**Proposal:                   Erection of rear extension.**  
**Location:                 4 South View Hoares Lane Babington Frome Somerset**  
**Applicant:               Mrs V Dale**  
**Application Number: 2021/1126/L1PA**

## Pre-Application Advice Report

<b>Mendip District Council</b>	<b>Site Address:</b> 4 South View, Hoares Lane, Babington, BA11 3RP	<b>Ref No:</b> 2021/1126/L1PA
<b>Summary of your proposal and Officer view:</b>		
<p>The proposal seeks to erect a part two storey and part single storey rear extensions with the rear single storey extension at an angle, matching the angle of the rear garden.</p> <p>In principle, the proposal is acceptable, with the proposed extension being to an existing dwellinghouse. The design and neighbouring impact has been assessed and expanded on further below.</p> <p>As assessed further below, the proposal as shown on the submitted plans is likely to be acceptable – the proposed design being inkeeping with the surrounding area and resulting in no harm with regards to the neighbouring residential amenities.</p>		
<b>Planning Policies, legislation and other information relevant to your proposal:</b>		
<p>The Council's statutory Development

Client **MR + MRS DALE**
 Job **PROPOSALS AT 4 SOUTH VIEW, HOARES LANE, BABINGTON.**
 Title **PROPOSAL DETAILS (ELEVATIONS)**

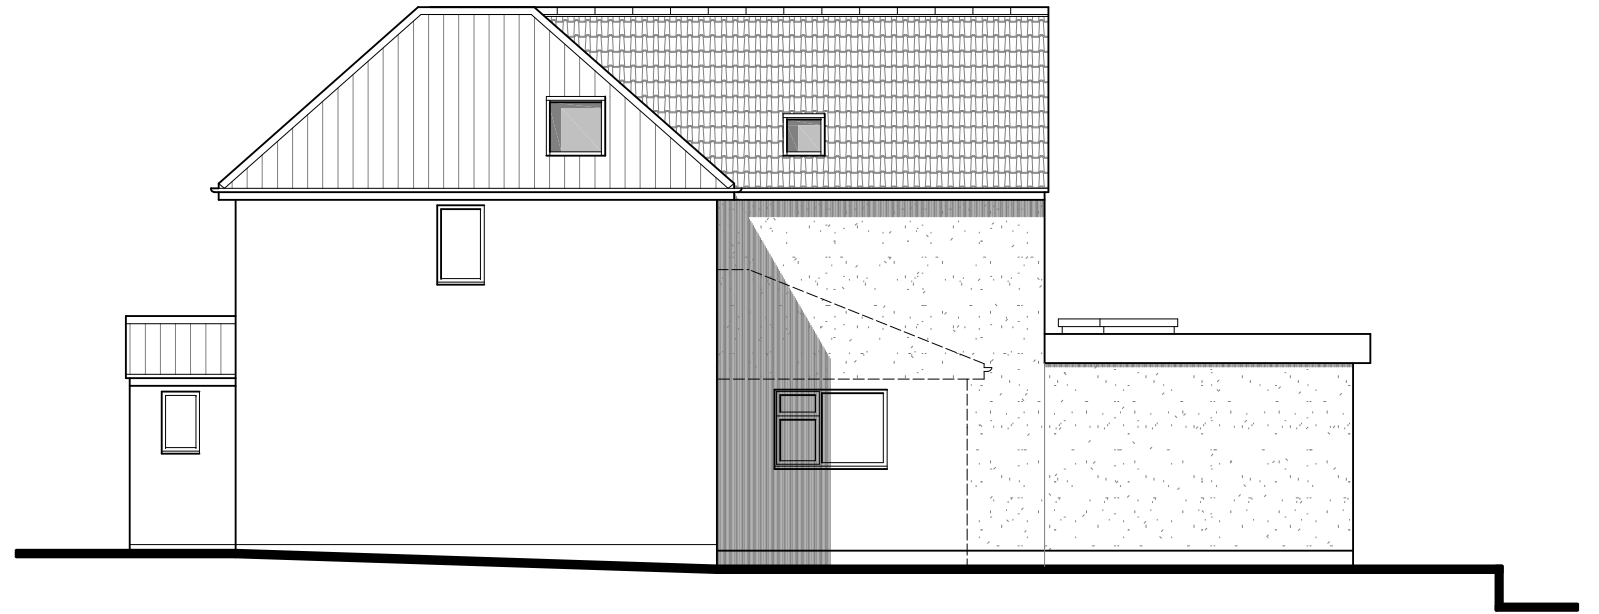
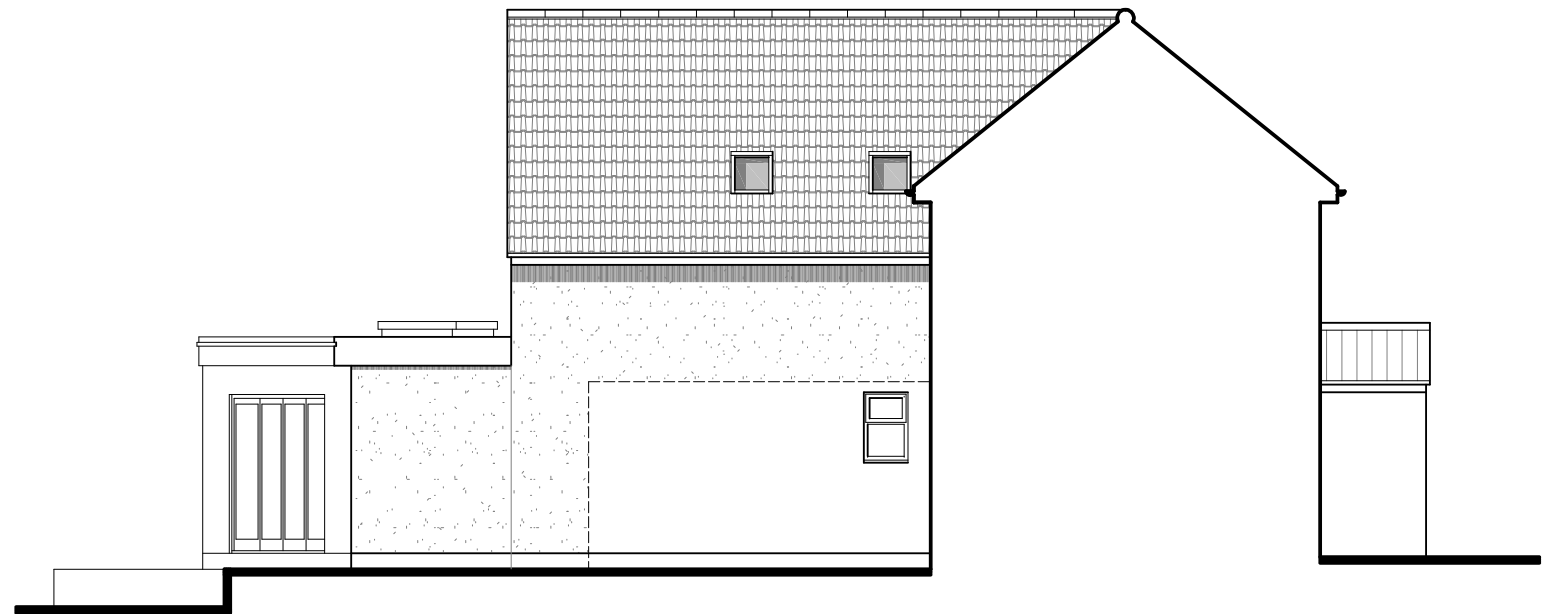
From the submitted Elevations and Floor Plans, it appears that the proposal would be broadly in-keeping with the host dwelling and neighbouring dwellings in terms of design and scale. The proposed materials have been noted on the plans to match the existing house and this would be acceptable.

The proposal as shown on the plans also seeks to include a single storey rear extension that is at an angle to the host dwellinghouse to follow the angle of the garden. With the proposal following the angle of the garden, as well as being small in scale, flat roofed and matching the proposed two storey extension, this is likely to be acceptable.

Client **MR + MRS DALE**
 Job **PROPOSALS AT 4 SOUTH VIEW , HOARES LANE , BABINGTON .**
 Title **PROPOSAL DETAILS (GROUND FLOOR PLAN)**
 Scales **1:50** Date **APRIL 2020** Ref No **2143 / 04 B**

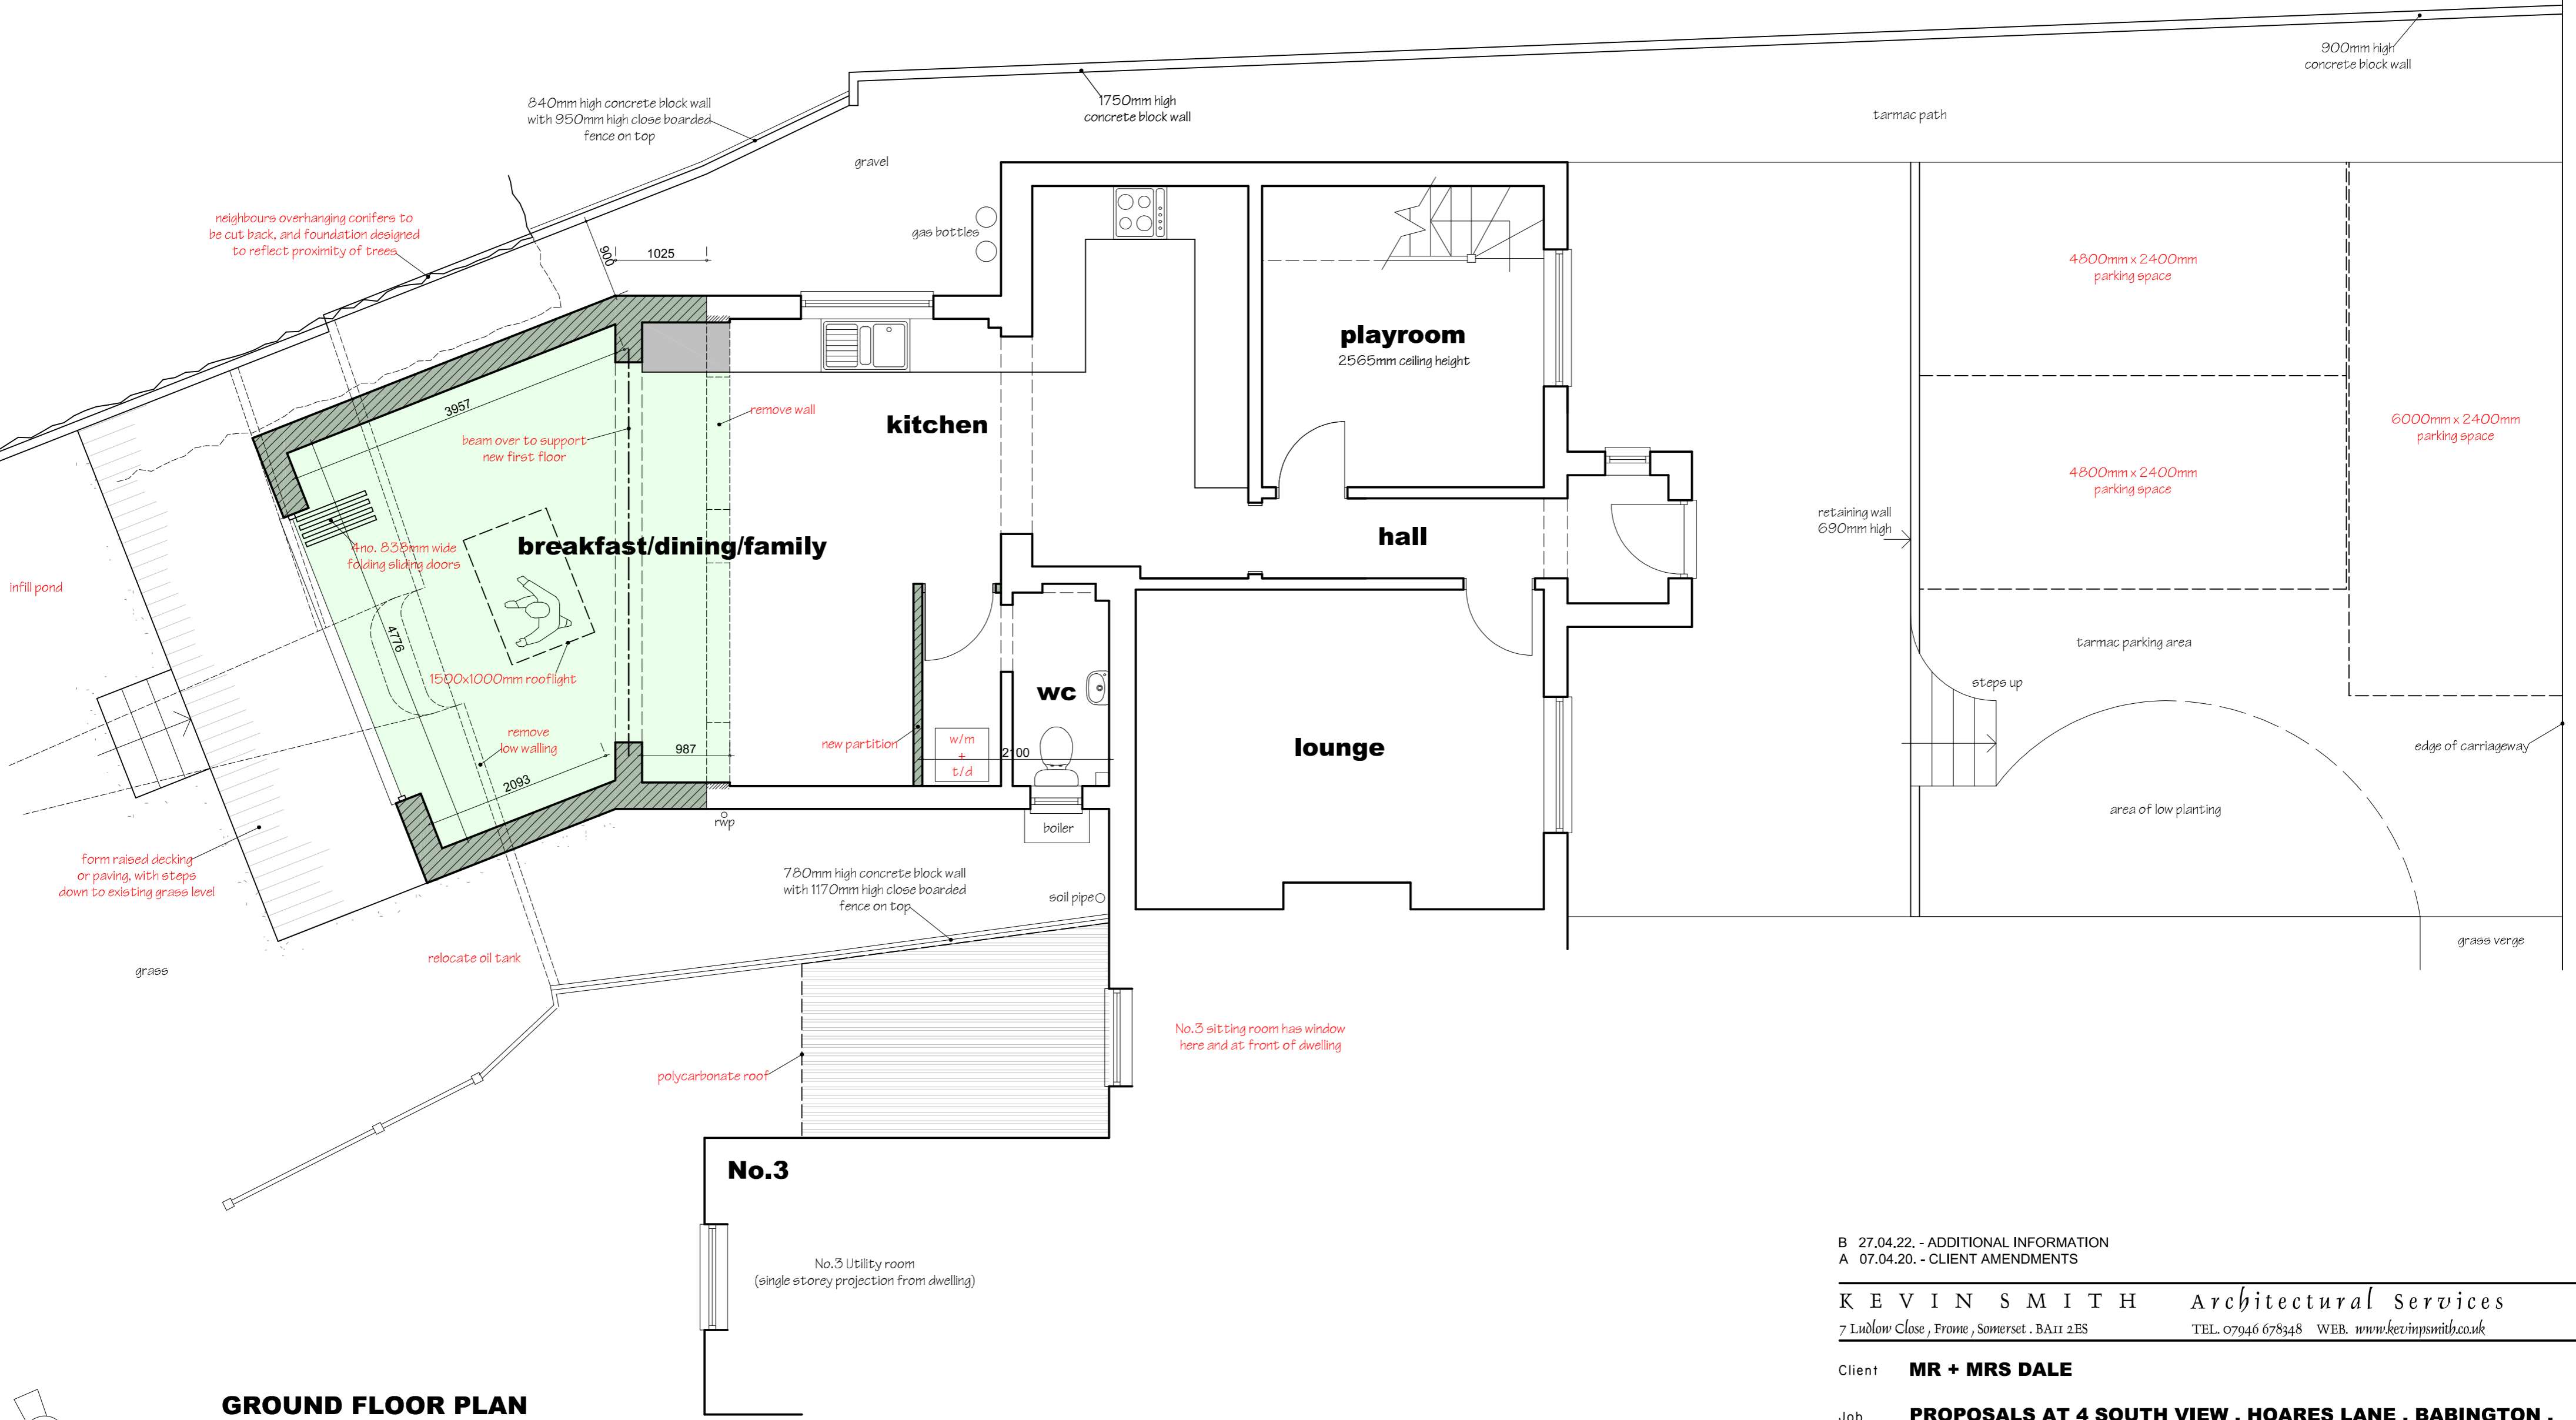
The most likely form of harm in this case is the potential of the two storey extension to have an overbearing impact in relation neighbouring properties. I can see from the submitted plans that this extension has been set in from the neighbouring boundaries to try to limit the impact. To the south, there is a separation distance of 2.5m and to the north a separation of 1m.

Title **PROPOSAL DETAILS (SITE PLAN, ROOF PLAN + SECTION)**

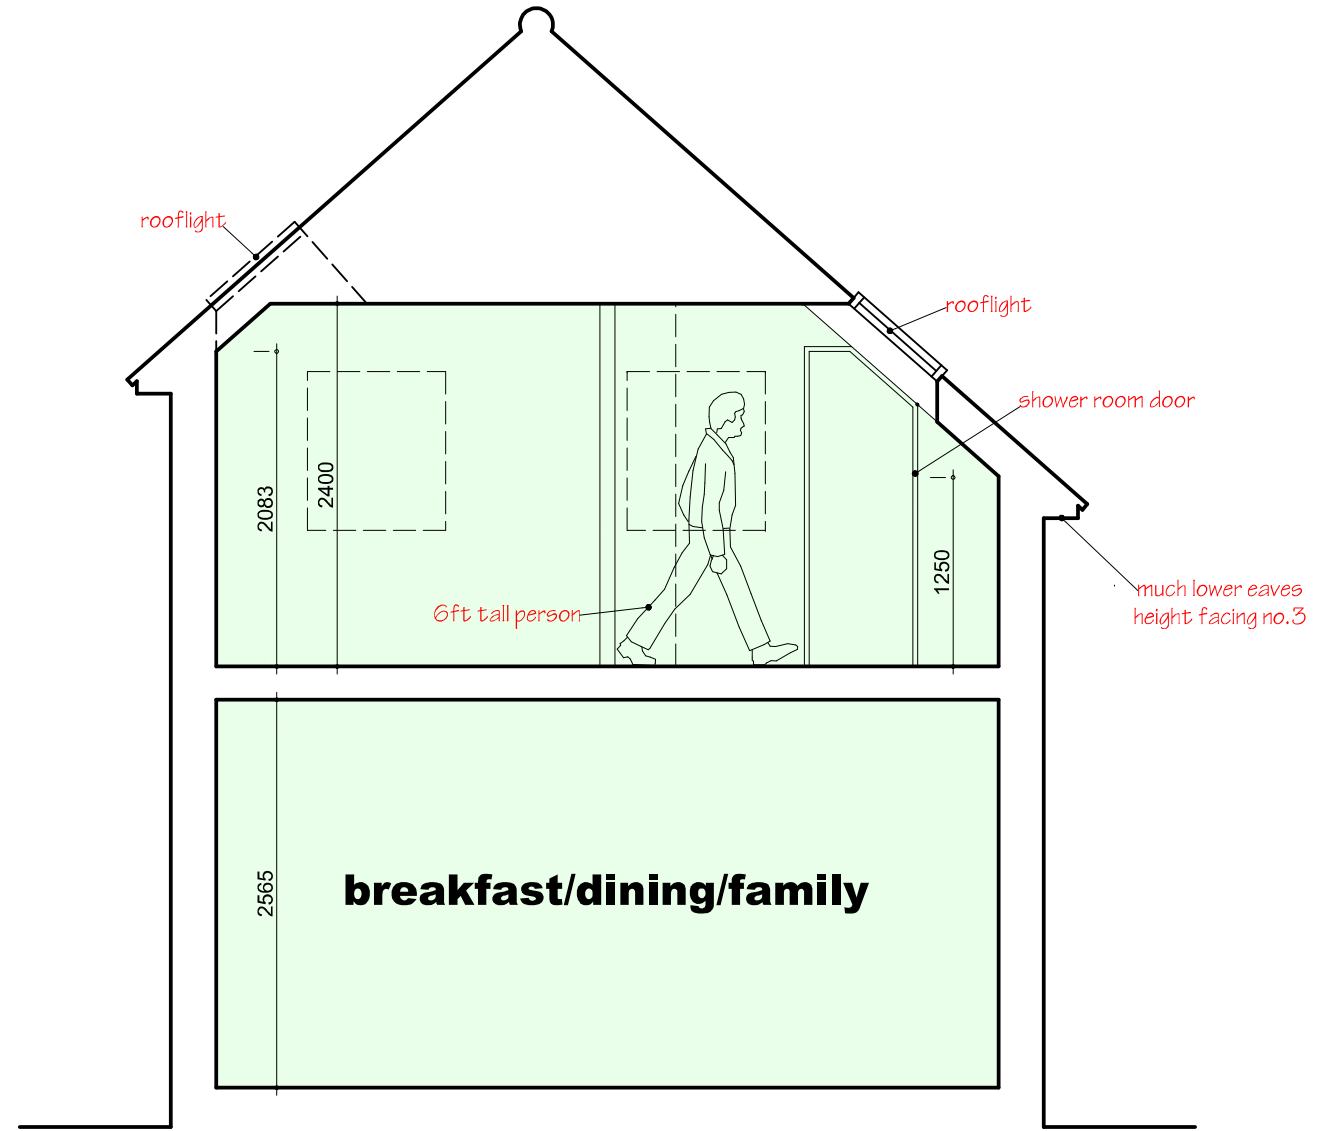
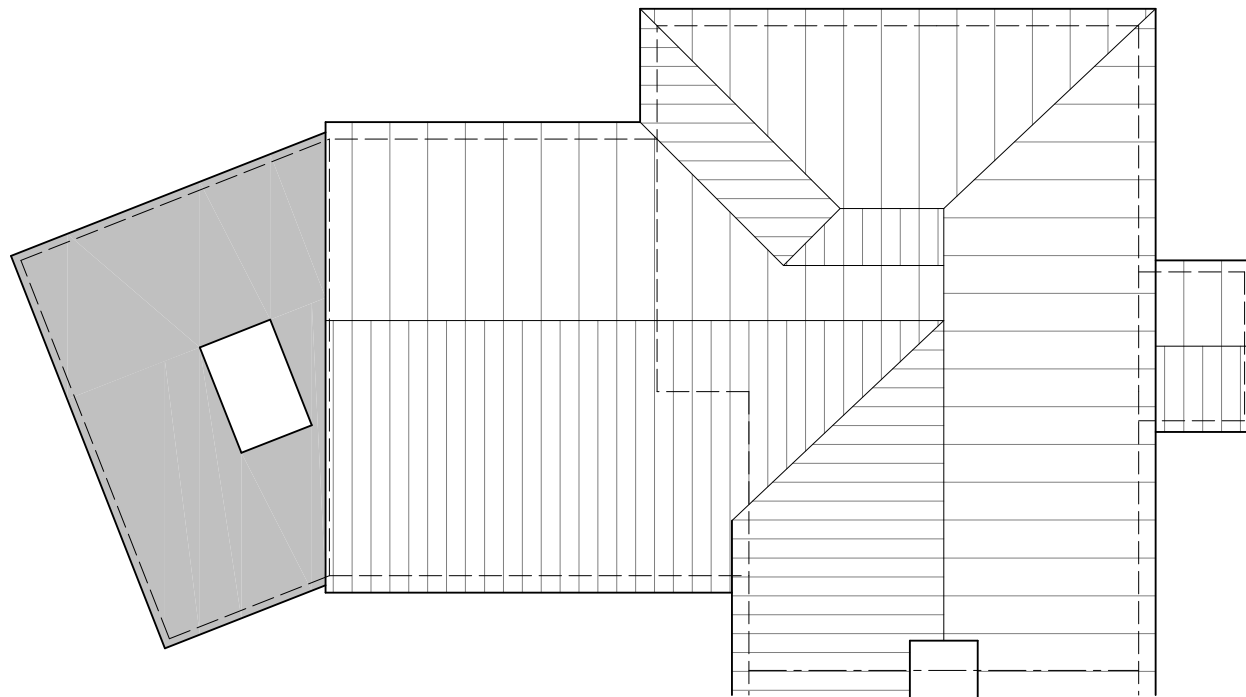
The proposal would add two additional bedrooms to the host dwelling, resulting in a four bedroom house. As per the Somerset County Council Parking Standards, this would require three parking spaces, or an increase in one space over the existing. On the submitted plan, the parking area is noted, but not the number of spaces.

From a Street View image, it appears that the parking area could accommodate three spaces so this is unlikely to be an issue, but these spaces would need to be included on the Proposed Site Plan.

- **Include existing and proposed parking arrangements, to standard sizes, on the Site Plan with the gain of one space shown.**
